**KIRKLEES METROPOLITAN COUNCIL
INVESTMENT & REGENERATION SERVICE**

Reference No: 2019/62/90237/W

Site Address: 27, Church Street, Golcar, Huddersfield, HD7 4PX

Description: Demolition of existing two storey extension and porch and erection of two storey extension with integral garage and single storey extension (within a Conservation Area)

| Rev.                                                | Date | Description |
|-----------------------------------------------------|------|-------------|
| 27CHS-18-PL02                                       |      |             |

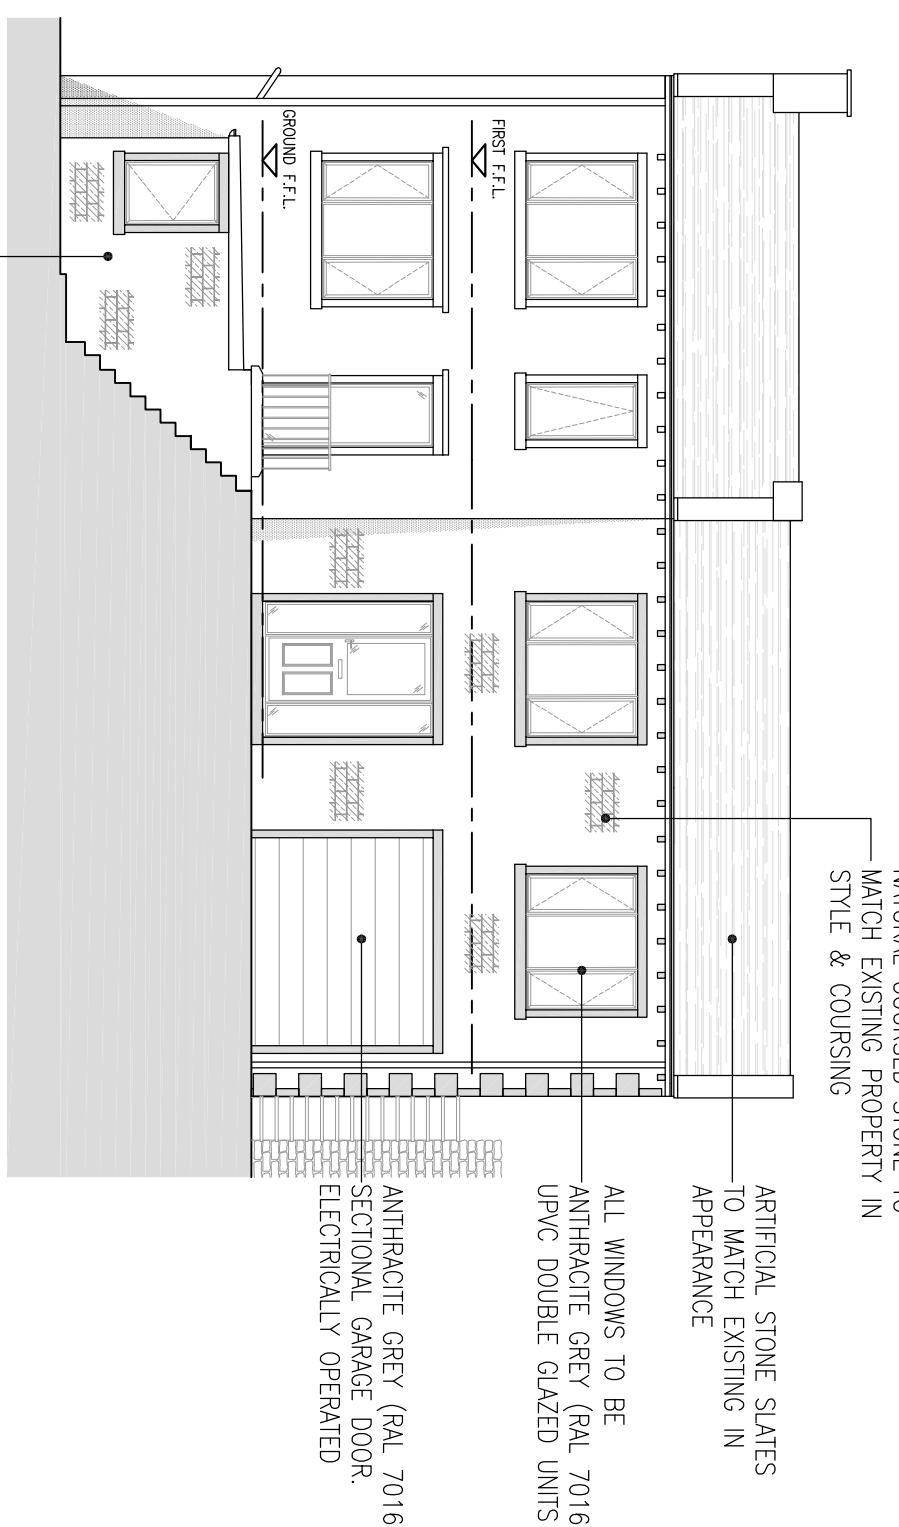
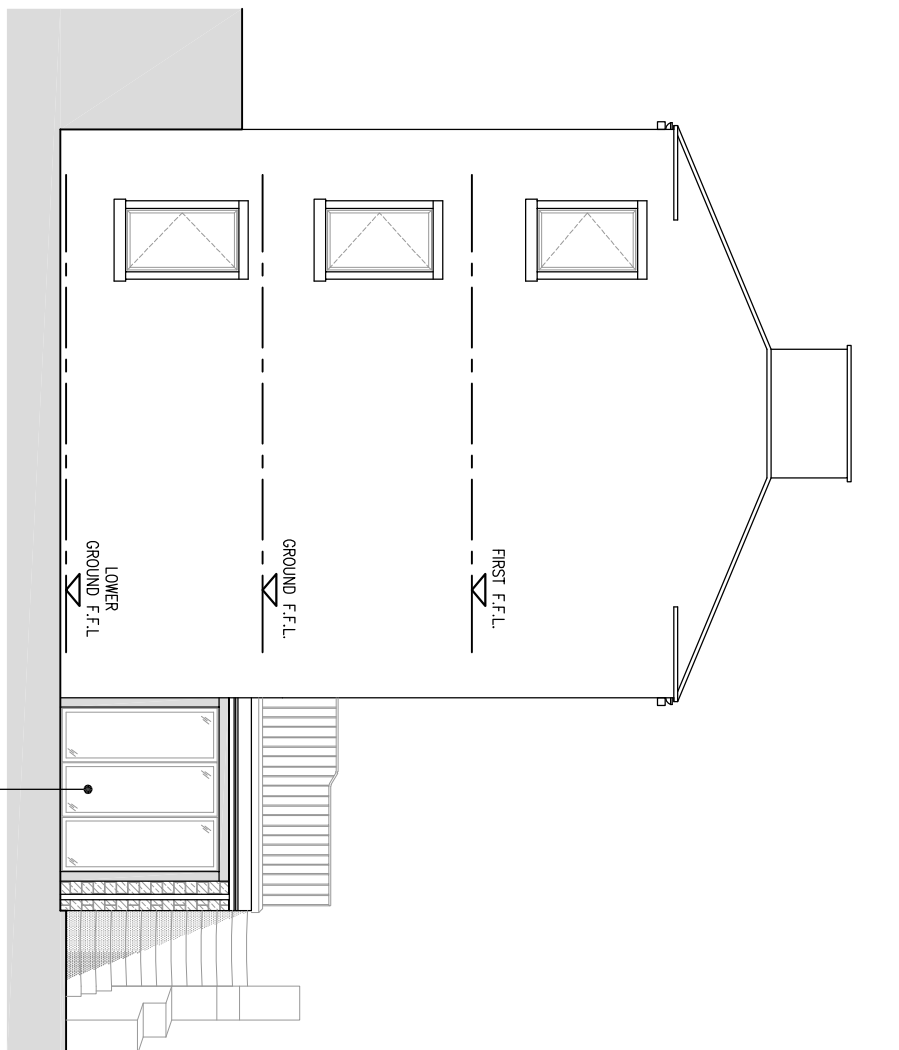
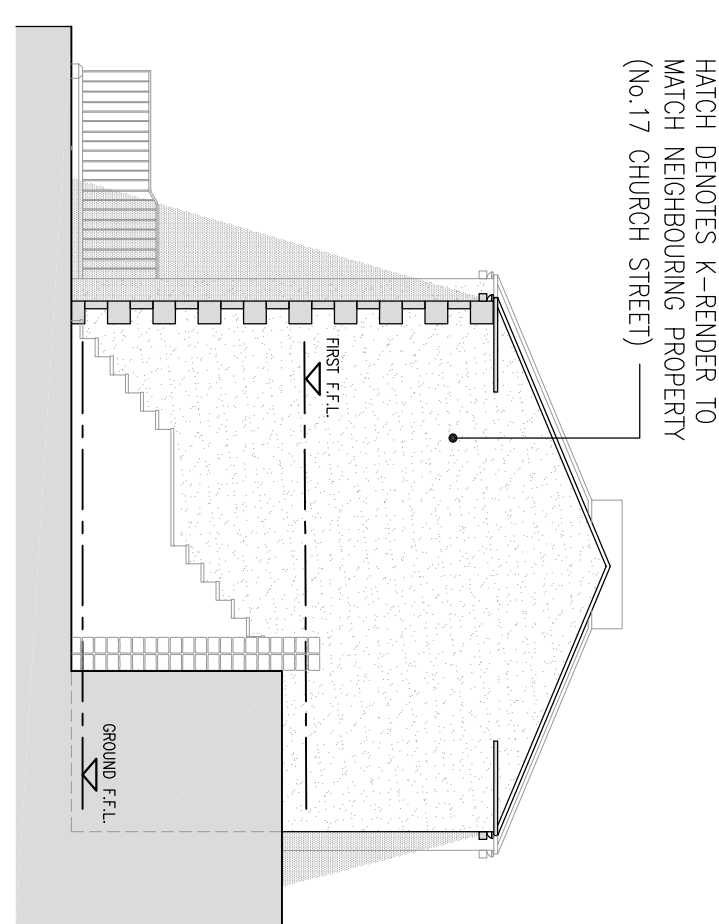
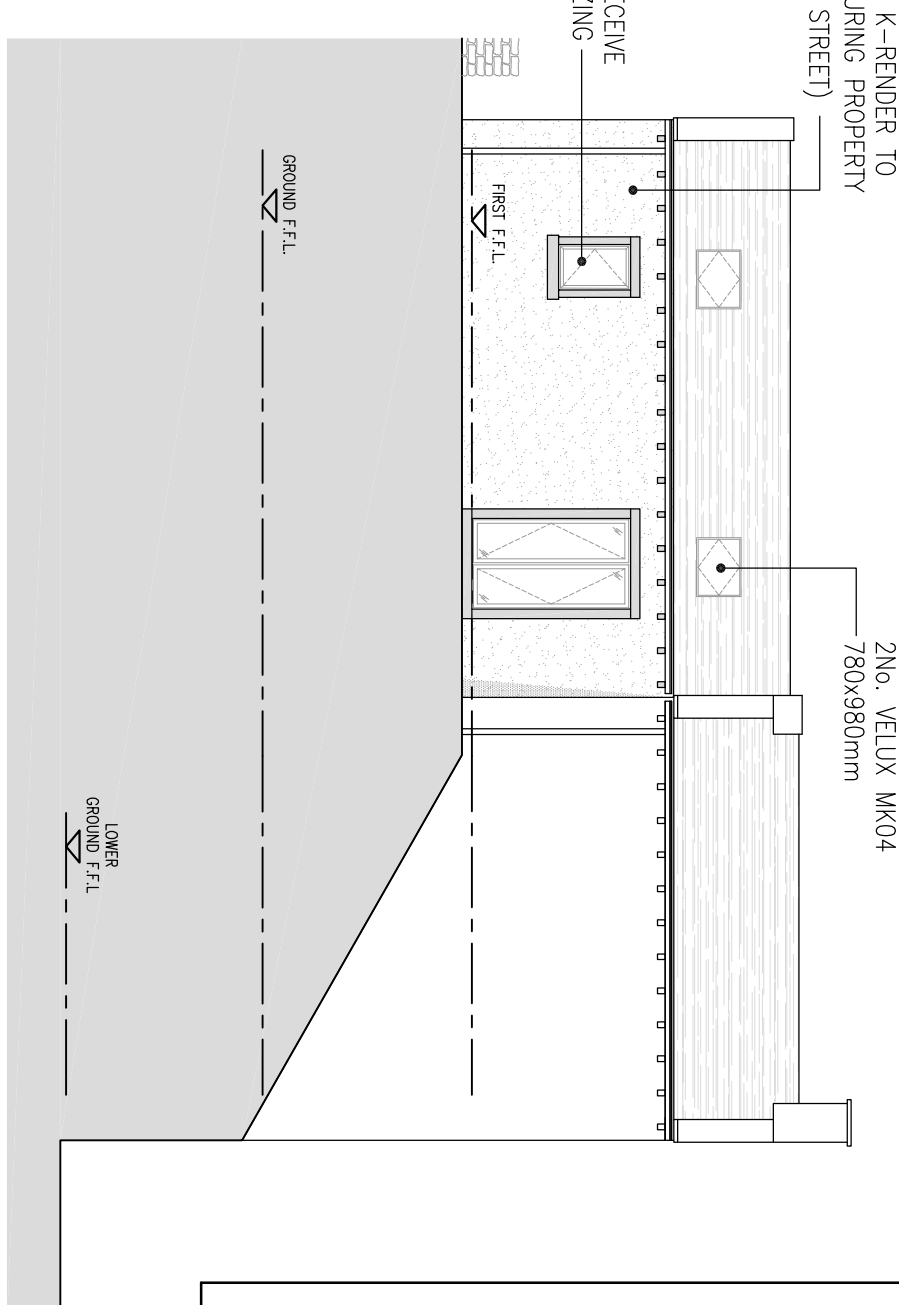
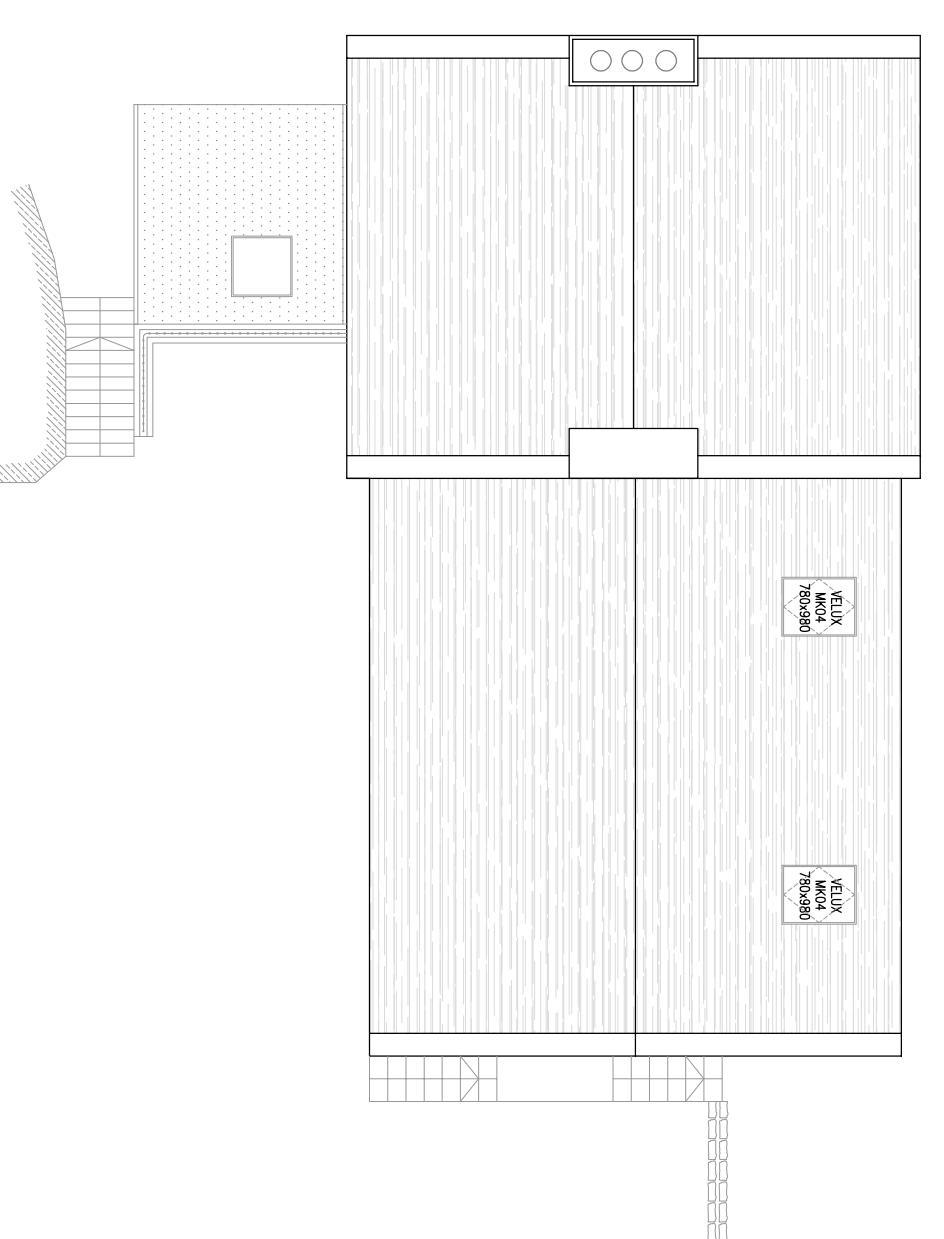
The Conservation Officer has suggested that they would prefer the windows to be a traditional colour such as off white, that the roof lights are of a conservation type and that materials should be submitted. These points have been raised with the agent who has confirmed that the applicant is not agreeable to the use of off white windows in the development but is agreeable to the use of conservation style roof lights and has confirmed that the render will be an off white/cream to match that used on no. 17.

Turning to the windows whilst anthracite grey windows are not supported by the Conservation Officer, this has to be balanced against the potential fall-back position and the other benefits which the development provides. It is acknowledged by Planning Officers that anthracite grey windows could be installed in the existing host property without the need for planning permission and that similar such dark coloured windows are present within the wider conservation area. Furthermore the application provides a significant benefit by the removal of an extension which in itself is considered to cause harm to the Conservation Area. In light of these matters, whilst the use of anthracite grey windows does cause some harm to the conservation area, this is considered to be less than substantial harm and this harm is outweighed by the public benefit of the removal of an unsightly extension and replacement with an extension which in all other respects has an acceptable impact on the conservation area.

Planning Officers have considered these points and the use of conservation style roof lights can be conditioned. With regard to materials the submitted plans detail that the stone would be natural of a style and coursing to match

the host property and the render would be of a similar colour to the adjacent no.17. Such arrangements are considered to be acceptable by Planning Officers, securable by condition.

4. The side and rear elevation of the hereby approved extension shall be rendered in a cream/off white colour before the extension is first brought into use.

5. The roof of the hereby approved two storey side extension shall be covered in tiles which shall in all respects match those used in the construction of the existing building.

6. The roof lights to be installed in the hereby approved extension shall be of a conservation style with a central glazing bar and installed flush with the roof of the extension, such roof lights shall thereafter be retained.
